COMMUNITY SERVICES DEPARTMENT

Subject: Ellicott Town Center Filing No. 1 Final Plat, Review #2 (SF-18-025)

ELLCOTT TOWN CENTER FILING NO. 1
A PORTION OF SECTION 14 & SECTION 15,
TOWNSHIP 14 SOUTH, RANGE 63 WEST OF THE 6th P.M.,
EL PASO COUNTY, COLORADO

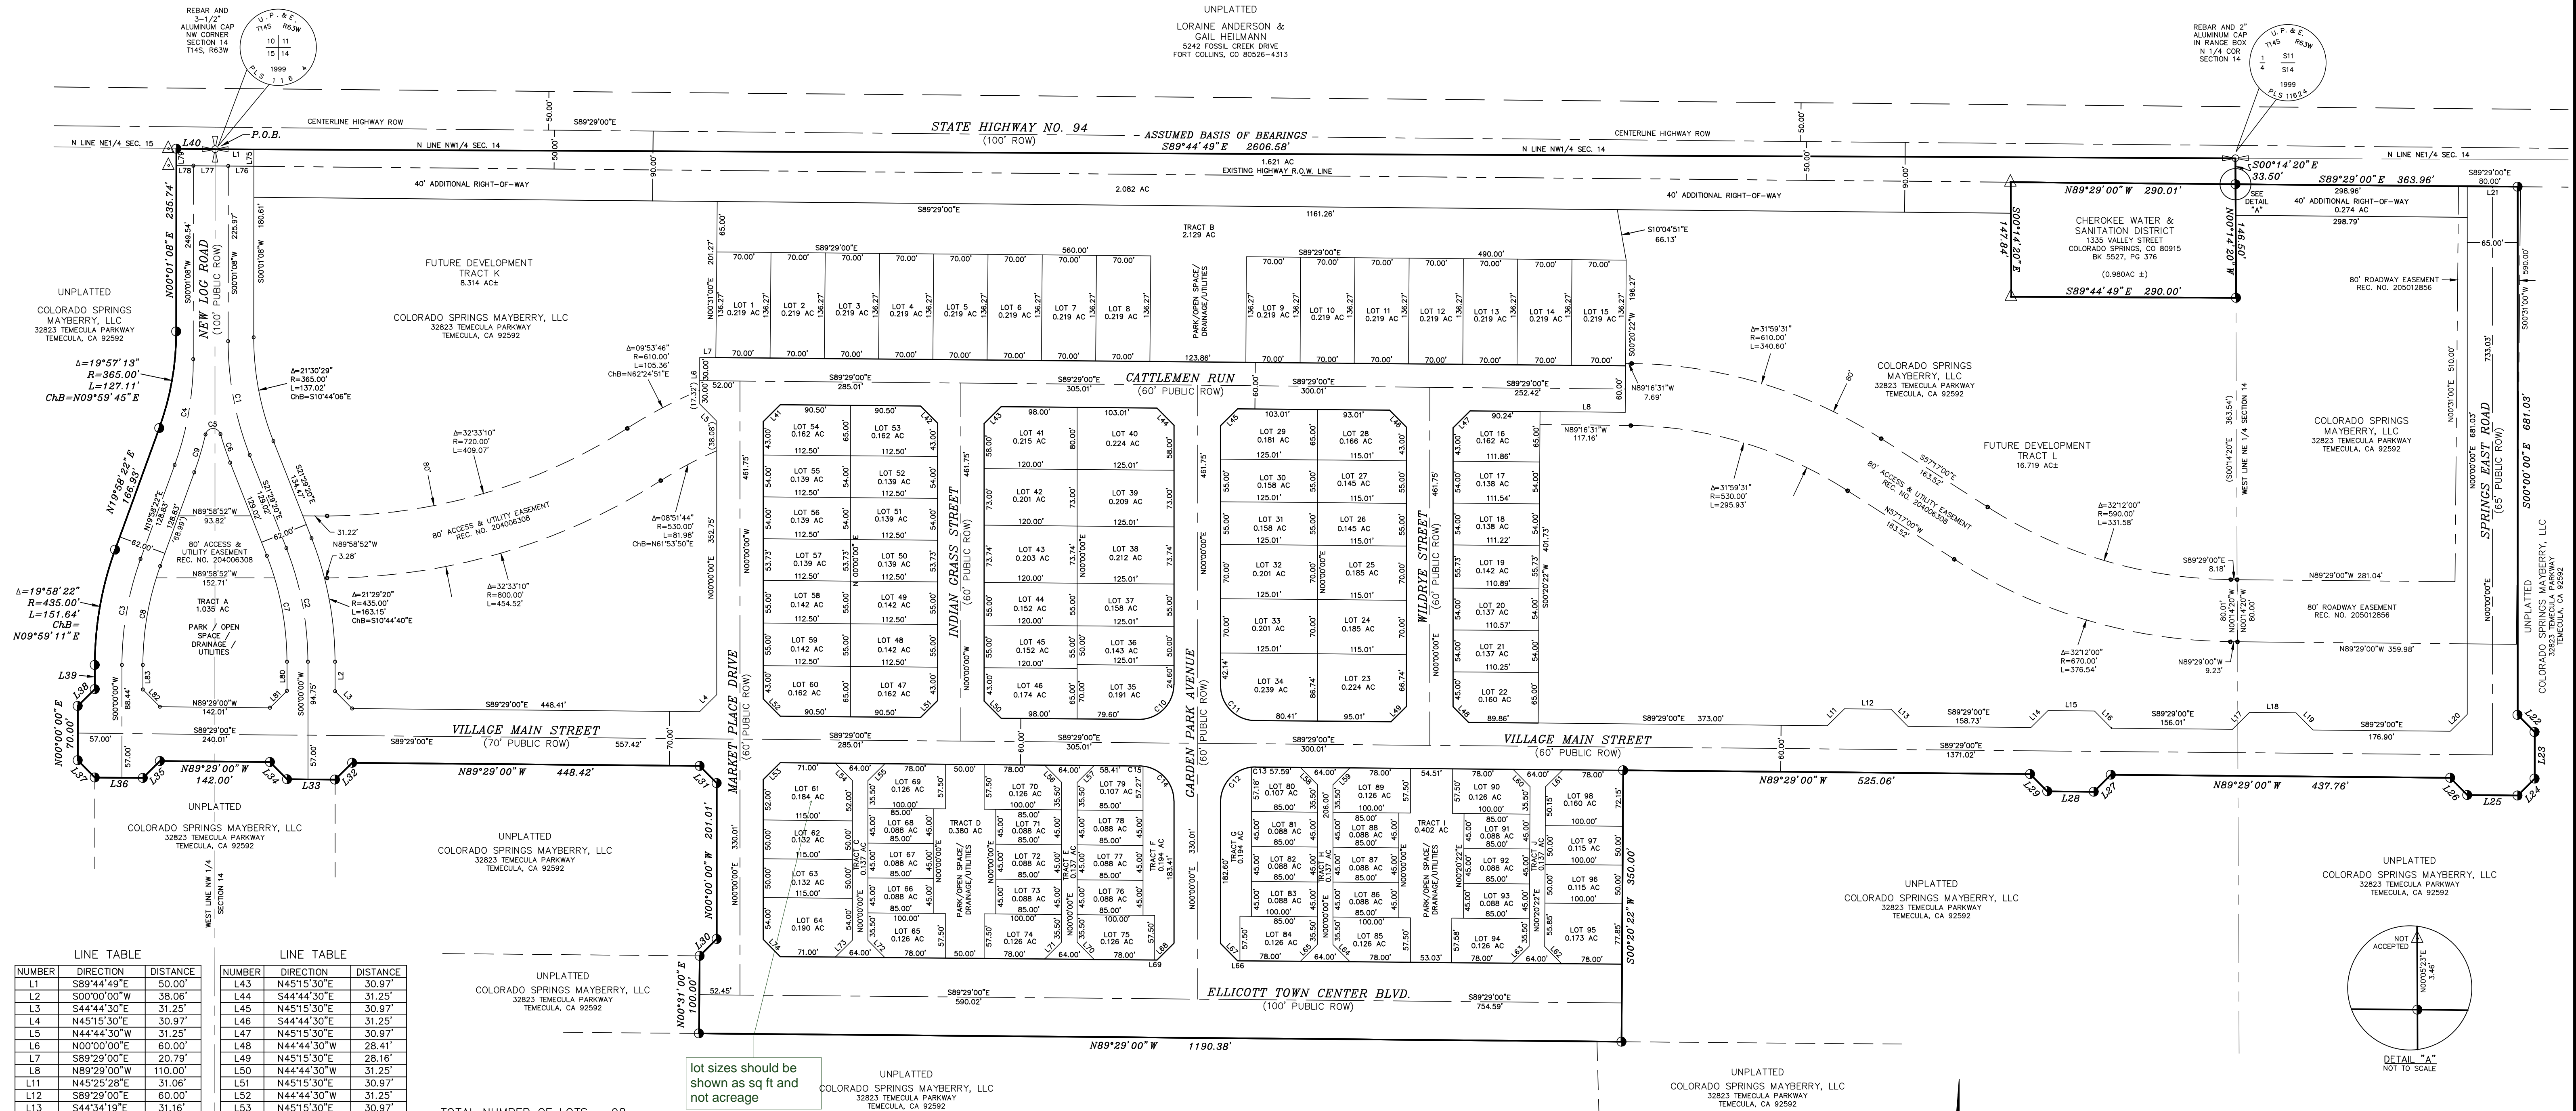
The Planning Division of the Community Services Department has reviewed the development application for Ellicott Town Center Filing No. 1 Final Plat, Review #2, and has no additional comments at this time. Staff acknowledges the inclusion of the 25-foot trail easement along East Highway 94, but is concerned about language in the Letter of Intent regarding the waiver of urban park fees. Please refer the applicant to the original review comments below, as endorsed by the Park Advisory Board on November 14, 2018, for clarification regarding the calculation and payment of urban park fees:

Staff also recommends the dedication of a 25-foot trail easement along the southern side of Highway 94 that allows for public access, as well as construction and maintenance by El Paso County of the Highway 94 Secondary Regional Trail, and that the easement be shown on the Final Plat and dedicated to El Paso County prior to the recording of the Final Plat.
